Ref: 2020 Springfield Road NMA

**PLANNING APPLICATION 11/00579/DPP: SPRINGFIELD ROAD, NON-MATERIAL AMENDMENT COVERING LANDSCAPE AND BIODIVERSITY ENHANCEMENTS**

The updated Biodiversity Scheme and subsequent changes are summarised below and illustrated in the attached drawing 2020SF-SK02 Biodiversity Scheme Plan:

Drawing No.	Revision	Scale @ AS	
2020SF-SK02	A	1:2000	
Drawn	Date	File No.	Reviewed By
MS	APR 2020	2020SF	MC

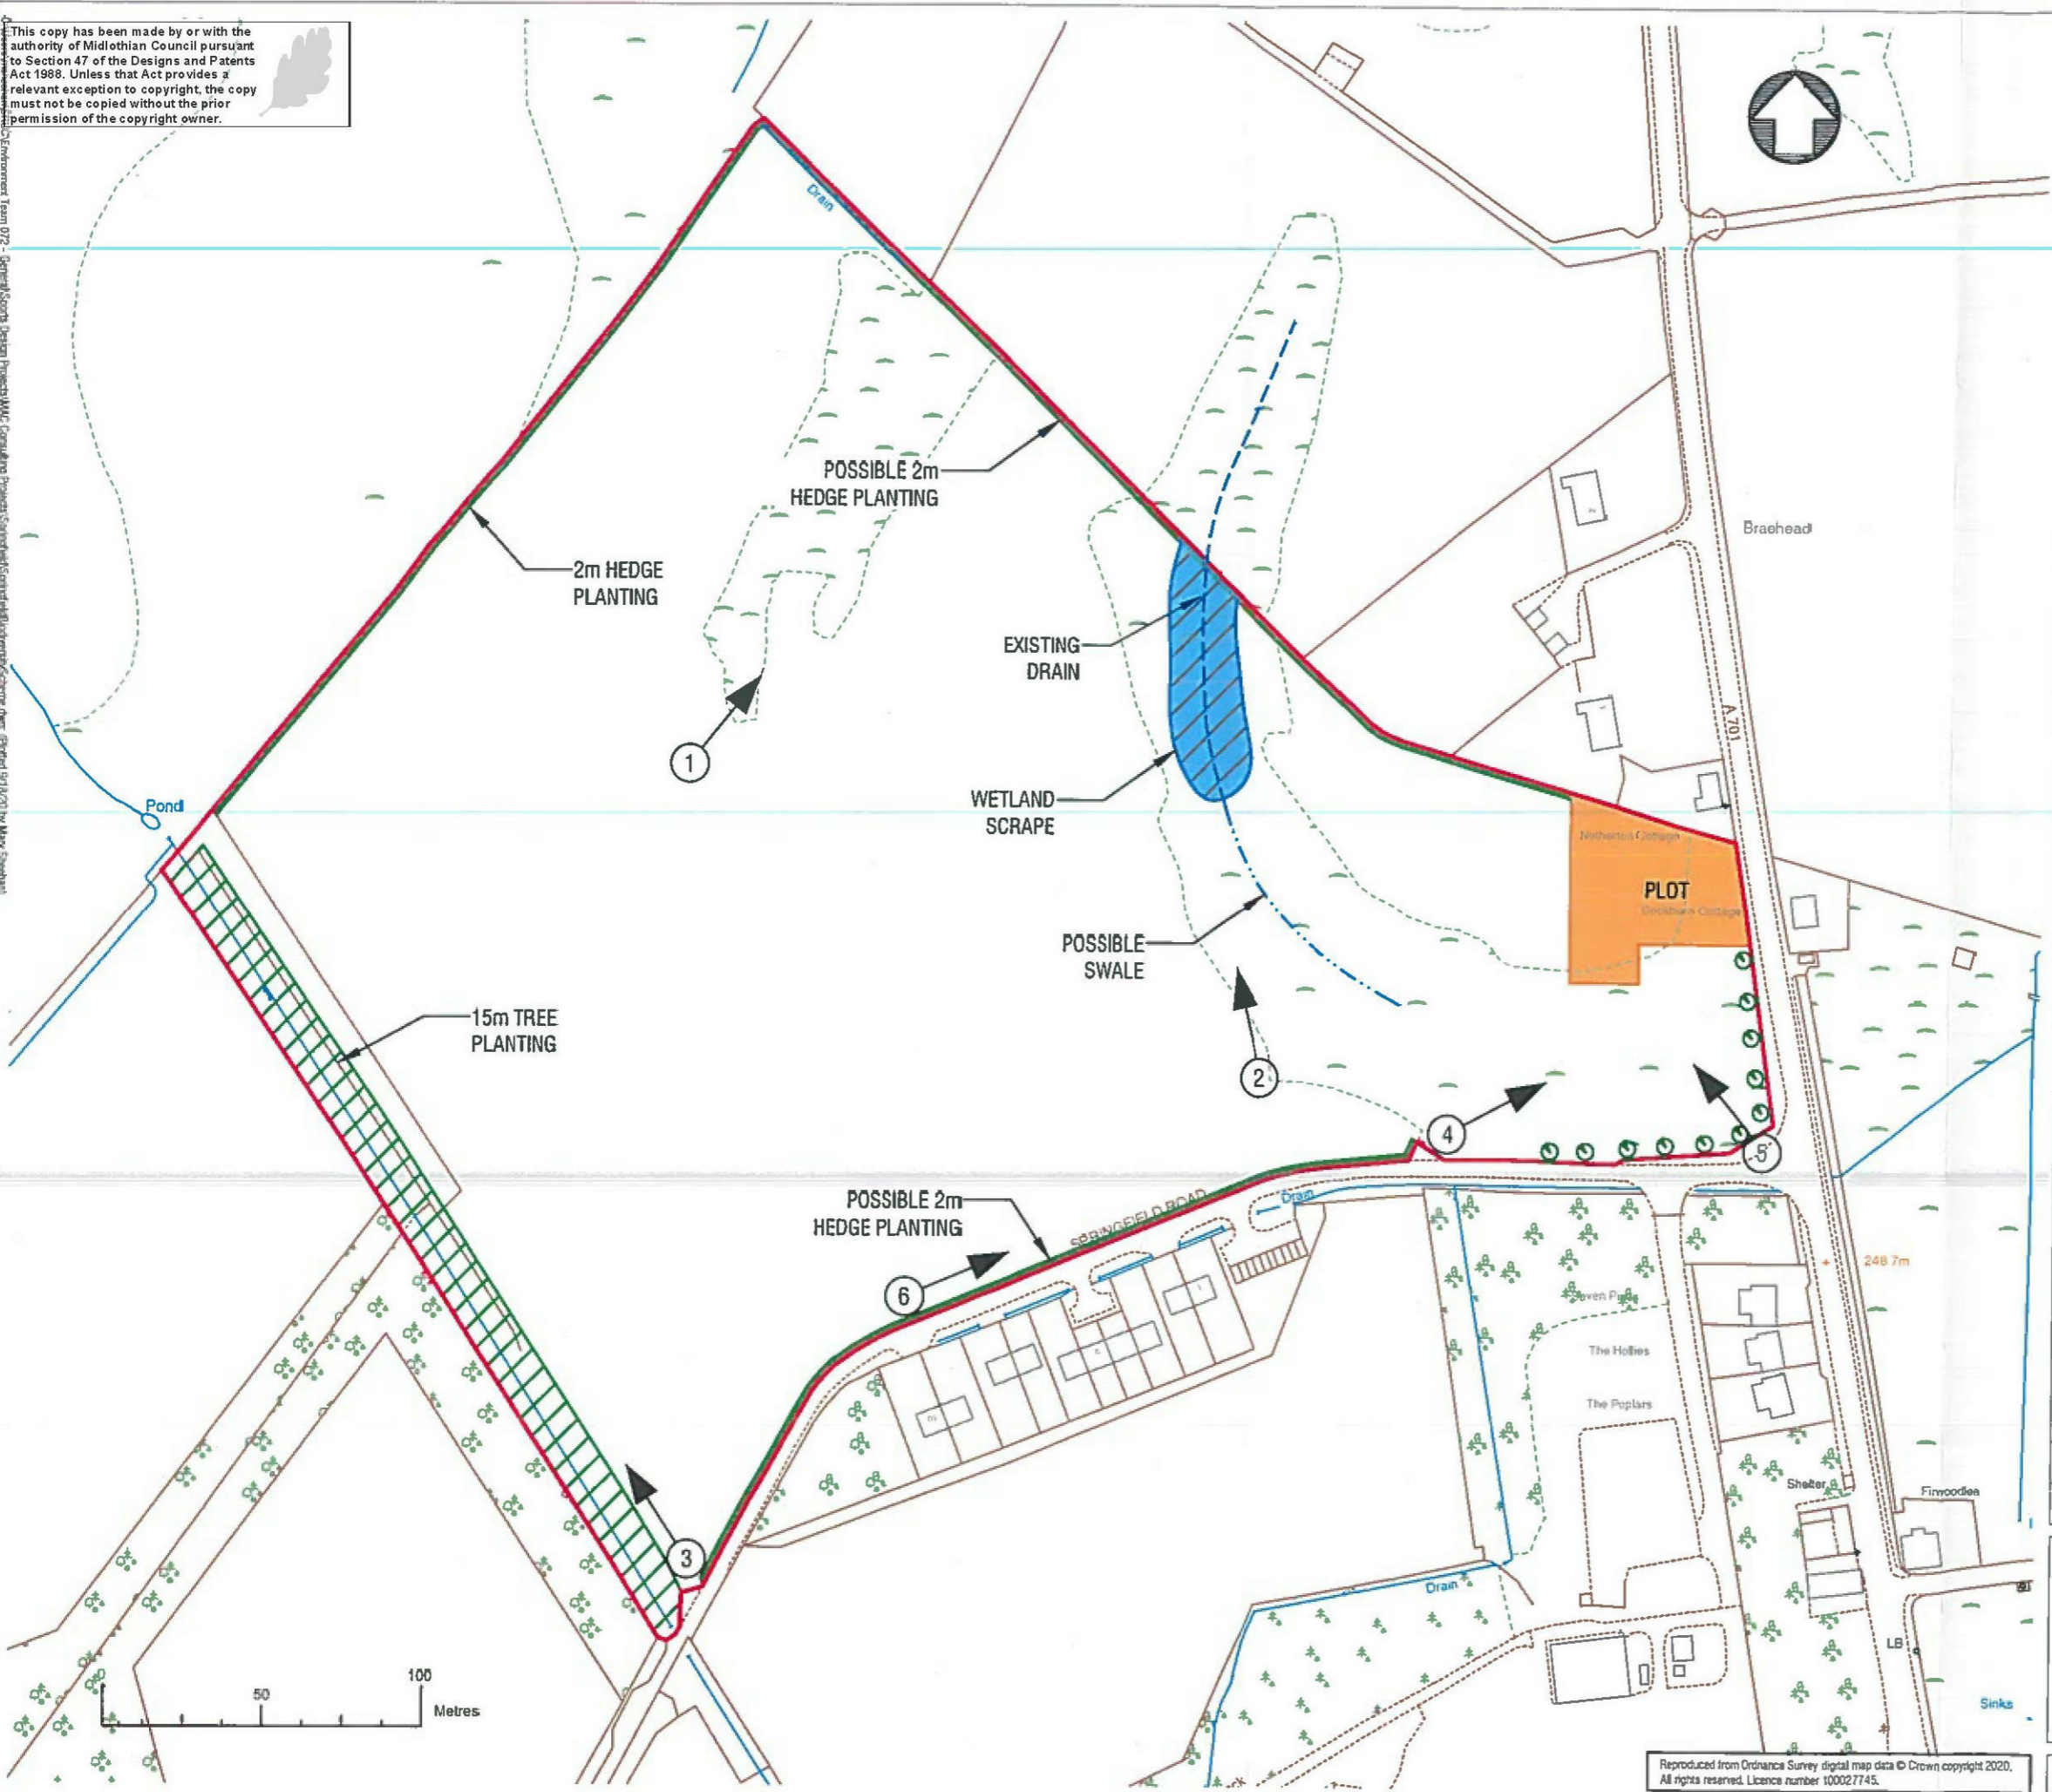
Original Proposal	2020 Proposal
(a) Woodland Creation	<ul style="list-style-type: none"> <li>• Specification as per the original proposal. <i>PROTECTION CHANGES</i></li> <li>• Extents limited to south western boundary only.</li> <li>• Native woodland creation is limited to the south western boundary of the land with a 15m strip of native broadleaved woodland to be created adjacent to the existing field boundary. Woodland proposed to the north western and north eastern boundaries in the original</li> </ul>

application shall be replaced by Hedge and Hedgerow Tree Planting as per (c)
(b) Woodland Management	No Change
(c) Hege and Hedgerow Tree Establishment	<ul style="list-style-type: none"> <li>• Specification as per original proposal.</li> <li>• Native hedge planting is extended in scope to include the northwest, northeast and southeast boundaries of the field (Hawthorn, Blackthorn, Dog Rose, Hazel, Holly).</li> </ul>
(d) Tree Removal	No Change
(e) Wetland Management	No Change
(f) Wetland Scrapes	No Change
(g) Grassland Management	No Change
(h) Dry Stand Dyke Repair	No Change
